**A122 LOWER THAMES CROSSING (REF: TR010032)
DEADLINE 6 WRITTEN REPRESENTATIONS**

E AND K BENTON LIMITED (AP1717)

Plate 41

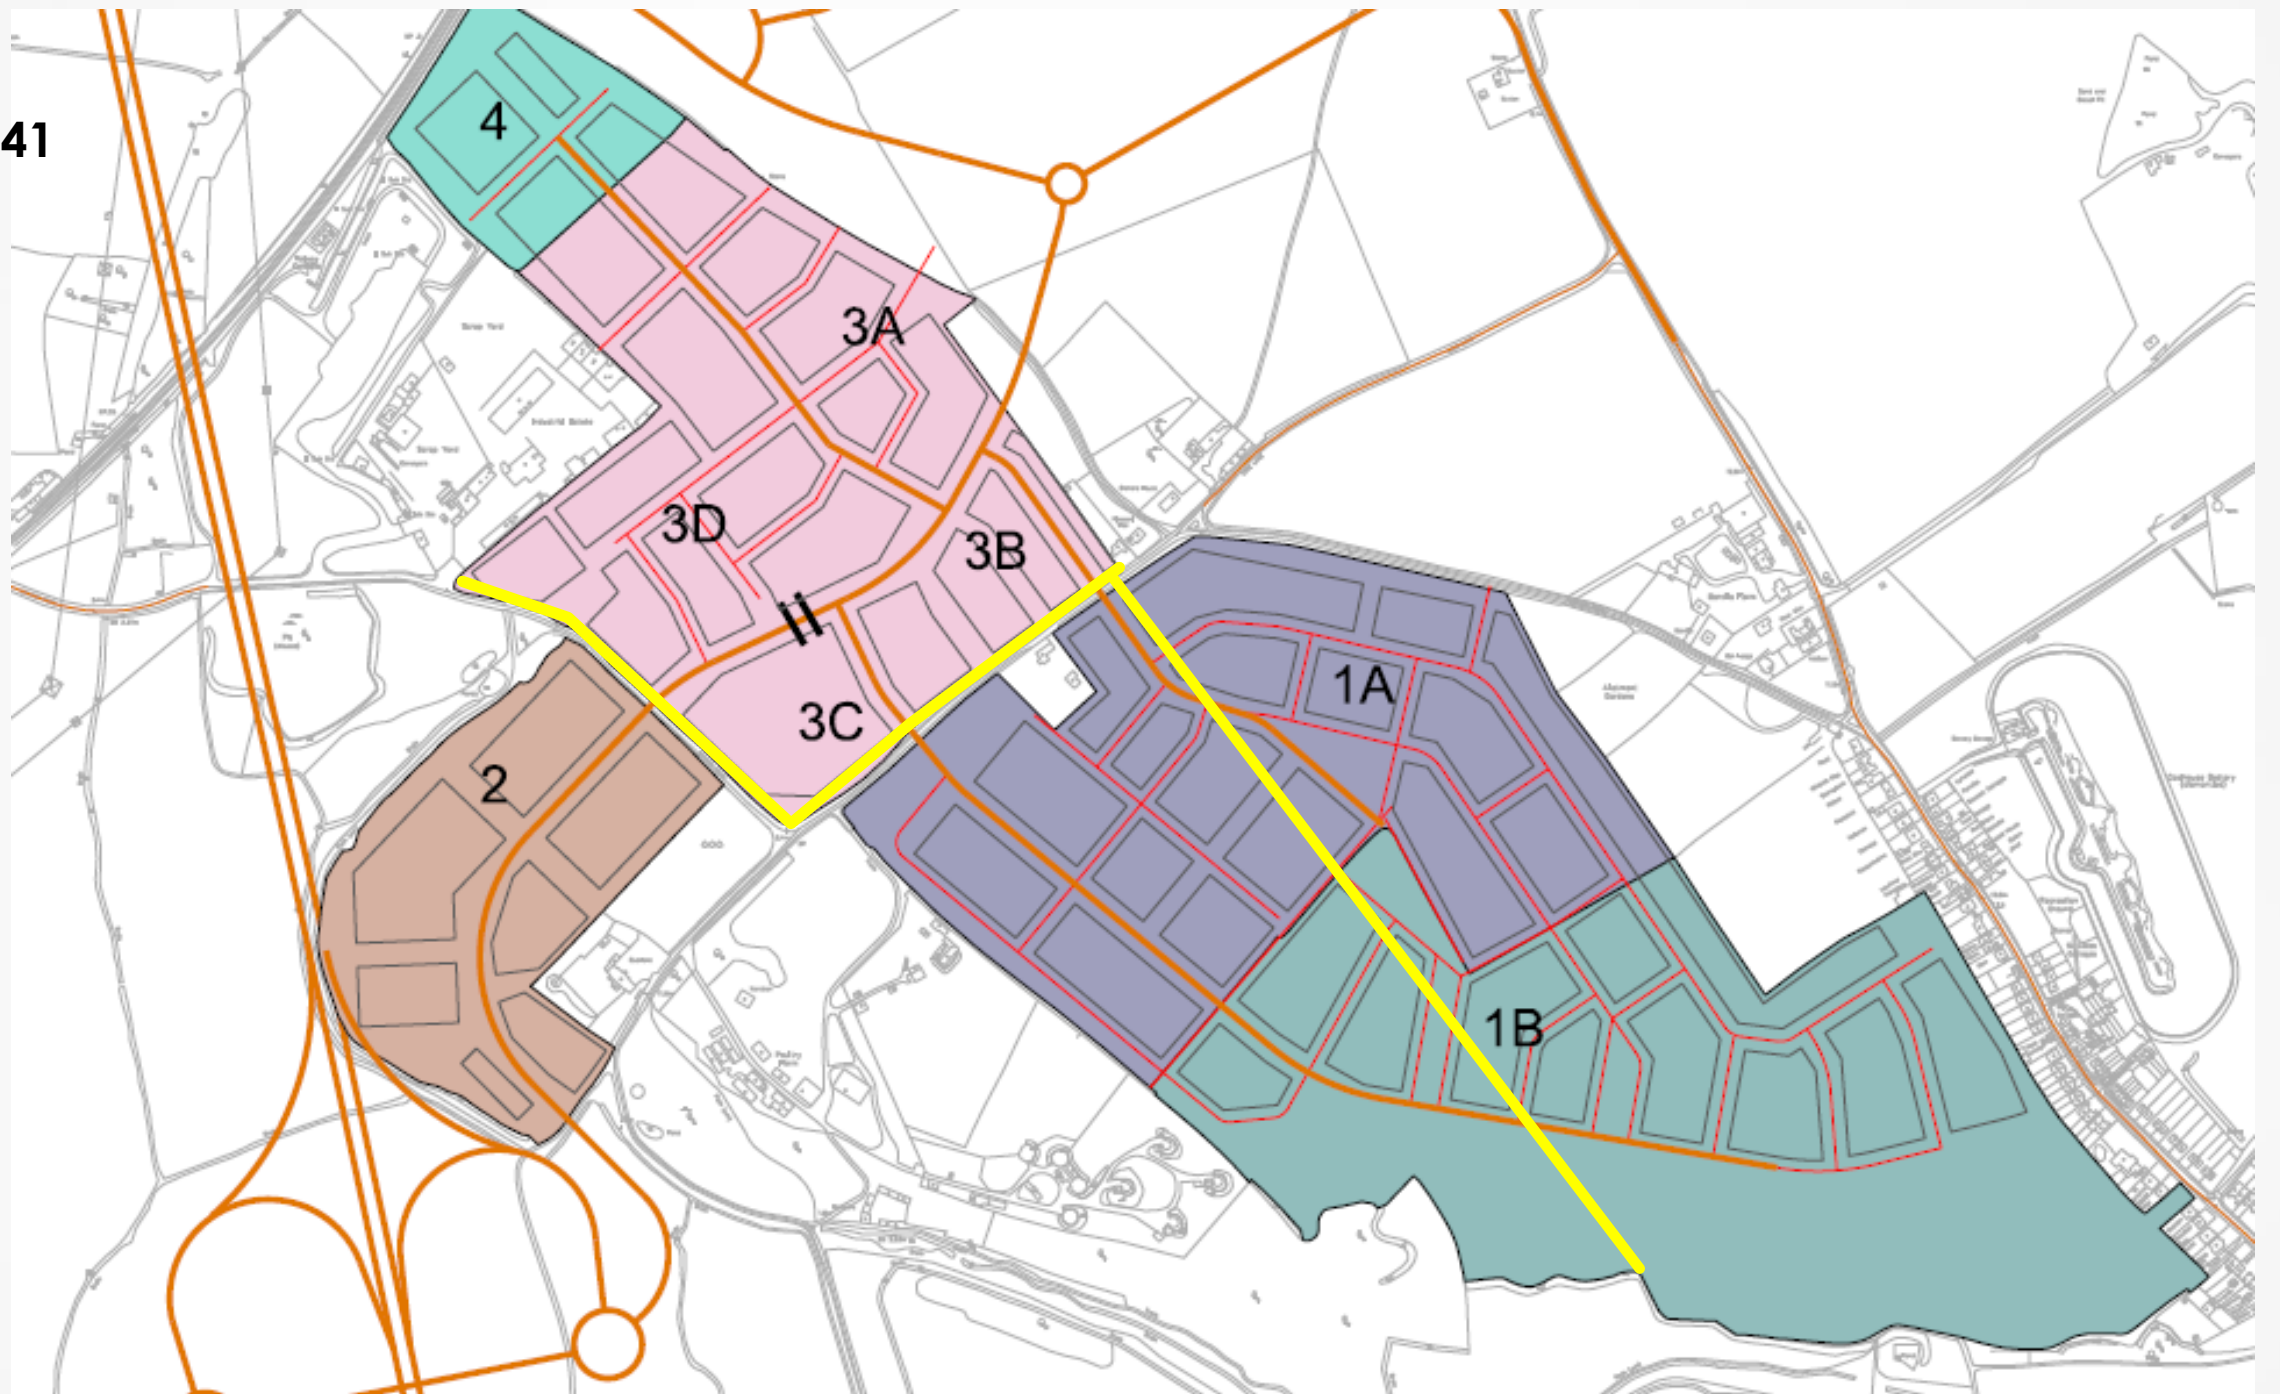
OVERVIEW	
Plate 42	E and K Benton Ltd ownership at South Ockendon is shown edged red on Plate 42 and Plan A.1 (Appendix A) of REP4-204 - Deadline 4 submission – 9.91 Draft Statement of Common Ground ('SOCG') between (1) National Highways and (2) E and K Benton Limited and amounts to approximately 504.63 acres (204.22ha).

<p>The extent of land-take (permanent, temporary possession and temporary possession with permanent rights) by the Project is overlaid on Plate 42 and Plan A.1 (Appendix A) of the draft SOCG shown shaded yellow and amounts to approximately 171.56 acres (69.43ha).</p> <p>The extent of the permitted Medebridge Solar Ltd solar farm scheme (as referenced in the draft SOCG) is shown as hatched black on Plate 42 and Plan A.1 (Appendix A) of the draft SOCG.</p>
Plate 43	<p>Plate 43 shows the E A Strategic Land (AP1539) South Ockendon Masterplan (2018) as part of the long-term promotion of land for strategic development at South Ockendon as part of Thurrock Council's developing Local Plan (a sustainable urban extension inc. housing 2,600 residential units, community, health and employment uses on Benton and Schatzmann).</p> <p>The land has been promoted by E A Strategic Land since 2018 (together with land in the ownership of the Schatzmann Family - AP1450).</p>

Plate 50

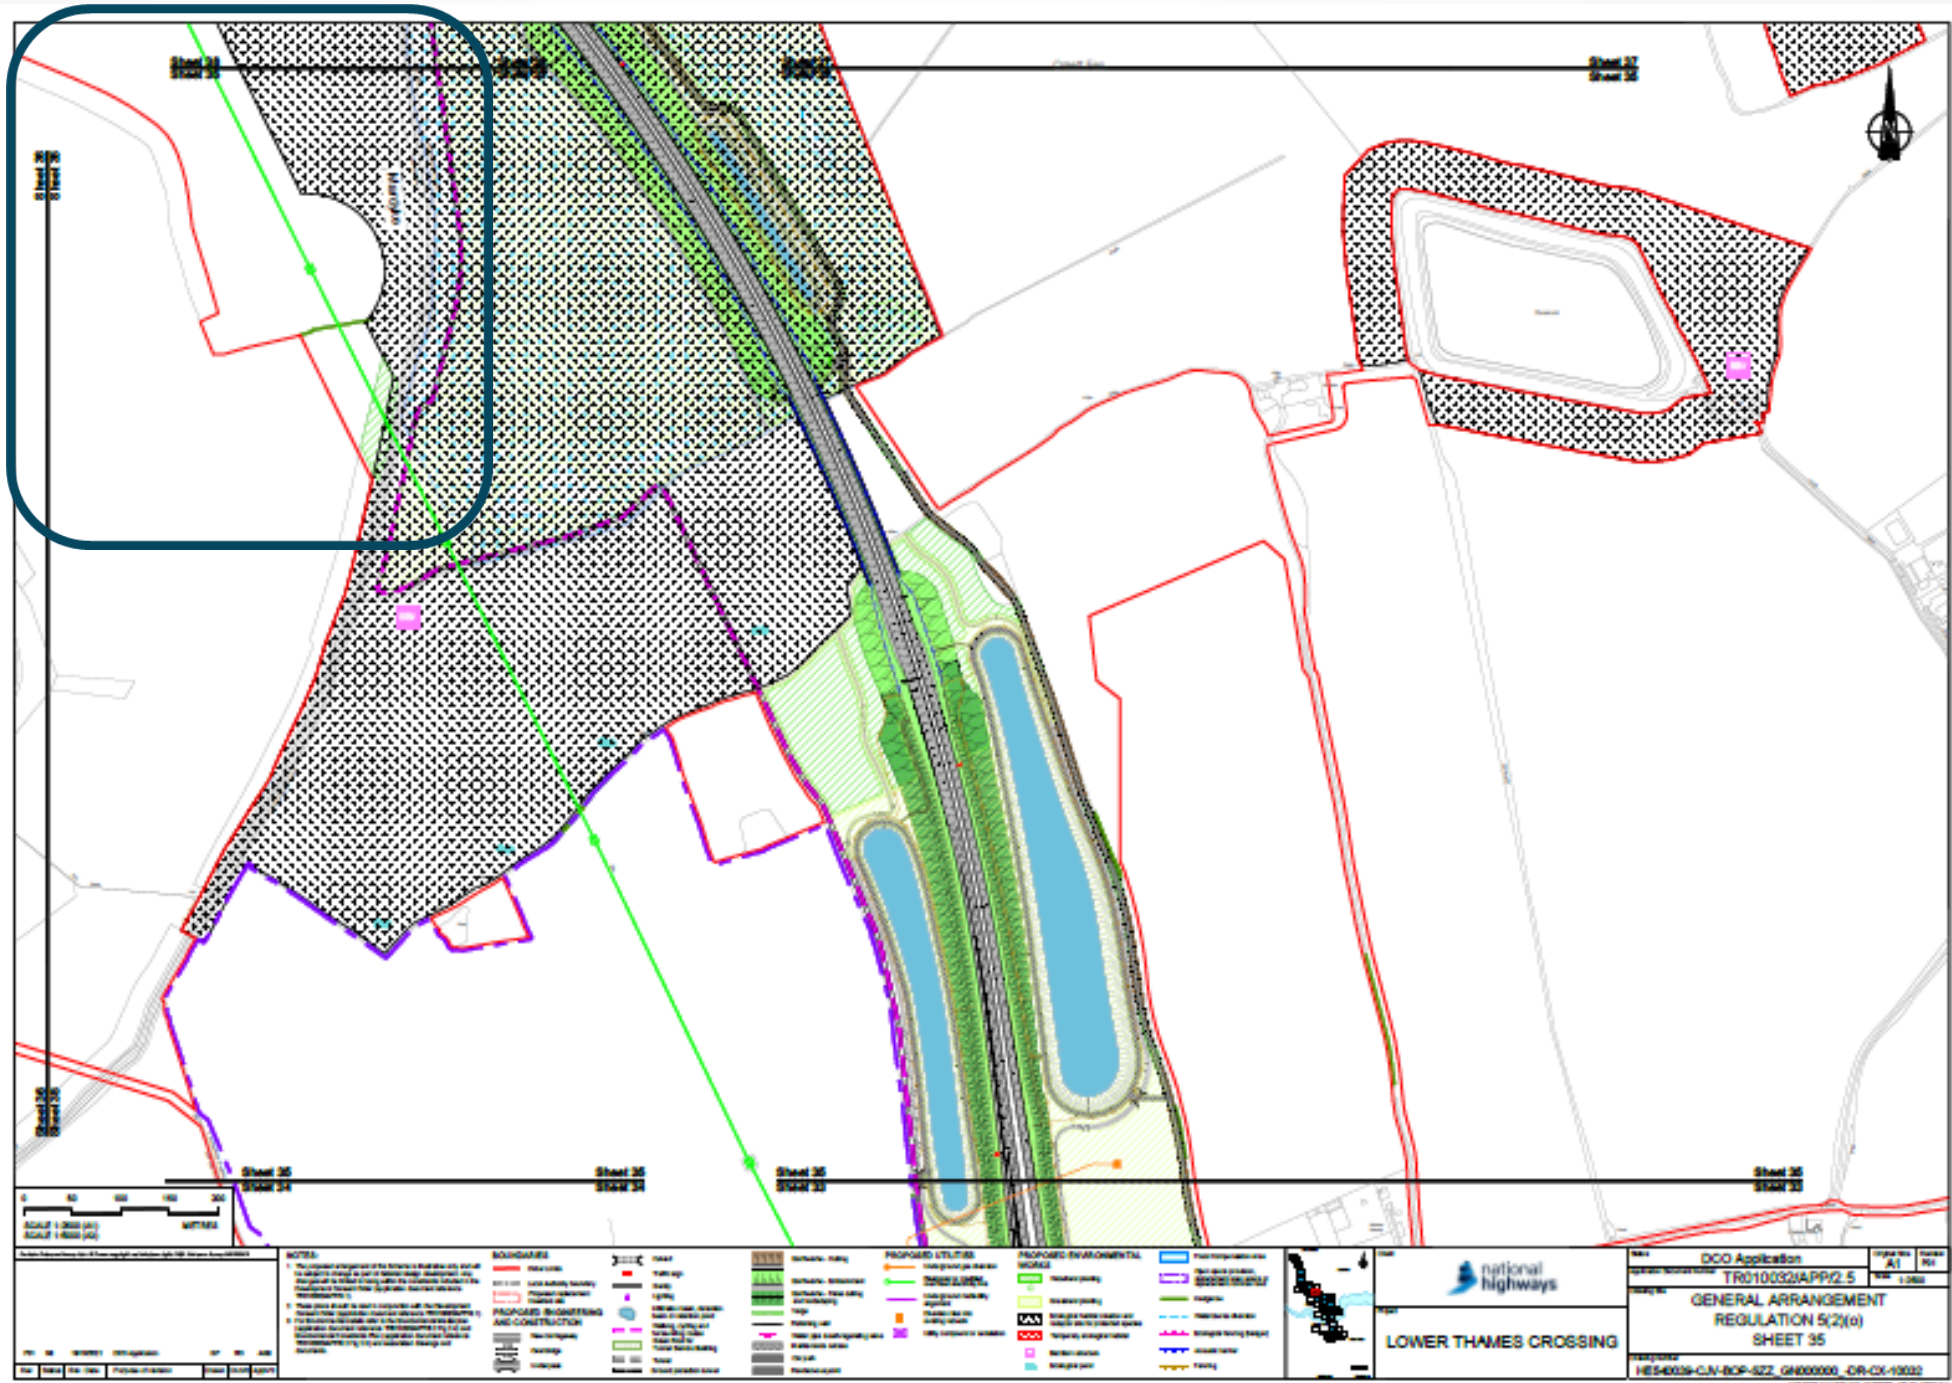
Plates 44 to 48	<p>Plates 44 to 48 show extracts from the Applicant's LTC Land Plans Volume C v.6.0 REP5-008 (sheets 35, 38, 39 and 41) with our client's ownership comprised within the areas in the blue boxes.</p>
ISSUE	POINTS RAISED
Ecological Mitigation & Flood Compensation Land	<p>Plates 49 & 50 – show the areas of Open Mosaic Habitat, Flood Compensation and Grassland planting proposed by the Applicant within the blue box.</p> <p>In total, the land area proposed to be permanently acquired for these purposes (including permanent land take for the main alignment) from our client equates to 63.80 acres or thereabouts.</p> <p>Further to our Deadline 1 representations at REP1- 335, our submissions in respect of Ecological Mitigation Land proposals are as follows:</p> <ol style="list-style-type: none"> 1) In the Applicant's response under 'Compensation Land (Generally) contained in the draft SOCG REP4-204 between the Applicant and E and K Benton, the Applicant refers to its preference to engage a 'competent authority' e.g. a local authority of similar body who has an established track record of maintaining such habitats. 2) It further states that this assists with compliance risks.

Plate 52

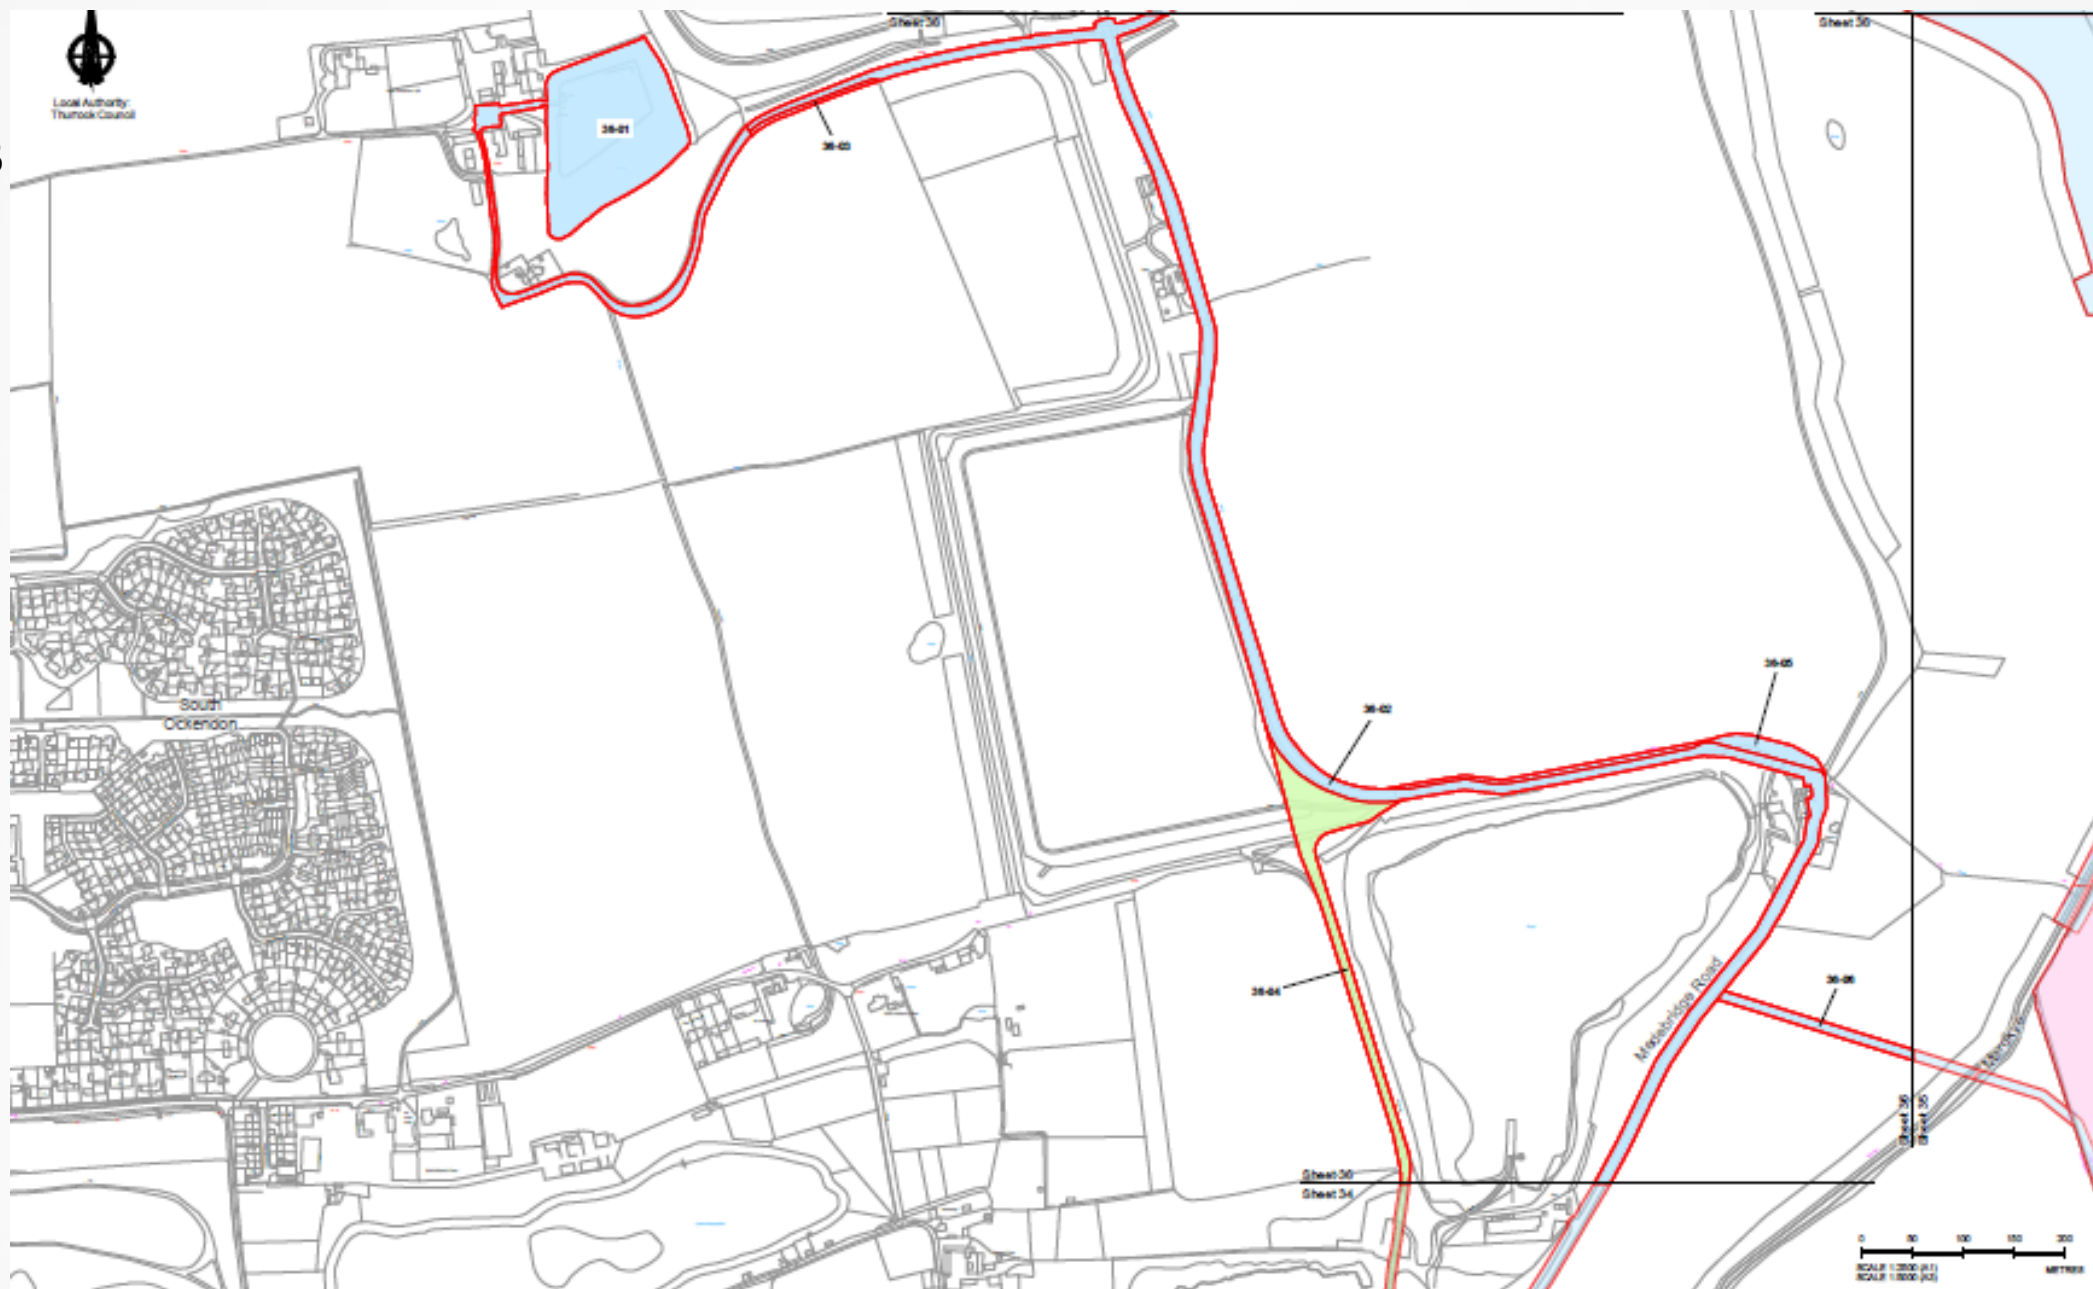
<p>Medebridge Road</p>	<p>Plate 52 – shows the general location of Medebridge road (coloured blue) as it serves our client’s land (including the permitted Medebridge Solar Farm – southern parcel) and the E A Strategic Masterplan land (shaded green)</p> <p>Plates 53, 54, 55 – show the Medebridge Road coloured blue on the Applicant’s Land Plans</p> <p>Plate 56 - show the E A Strategic Masterplan with a broad entry point from Medebridge Road marked with an arrow</p> <p>Our submissions are as follows:</p> <p>We would request a commitment from the Applicant under the Stakeholder Actions and Commitments Register (‘SACR’) to</p> <ol style="list-style-type: none"> 1) include landowner representatives and c in the Traffic Management Forum from the perspective of both protection of existing users and in respect of future joint use of the Medebridge Road for construction purposes associated with development at South Ockendon; 2) form a technical working group of E A Strategic Land, other users and Applicant’s appointed design and build contractors to agree a methodology and timetable for works to enable E A Strategic Land development and existing use requirements to be satisfied; and 3) ensure that suitable mitigation is in place to address any adverse effects of the Project on future development at South Ockendon 4) agree the works that are required and how those would be implemented to the Medebridge Road during the Applicant’s use and the condition of the road post use.
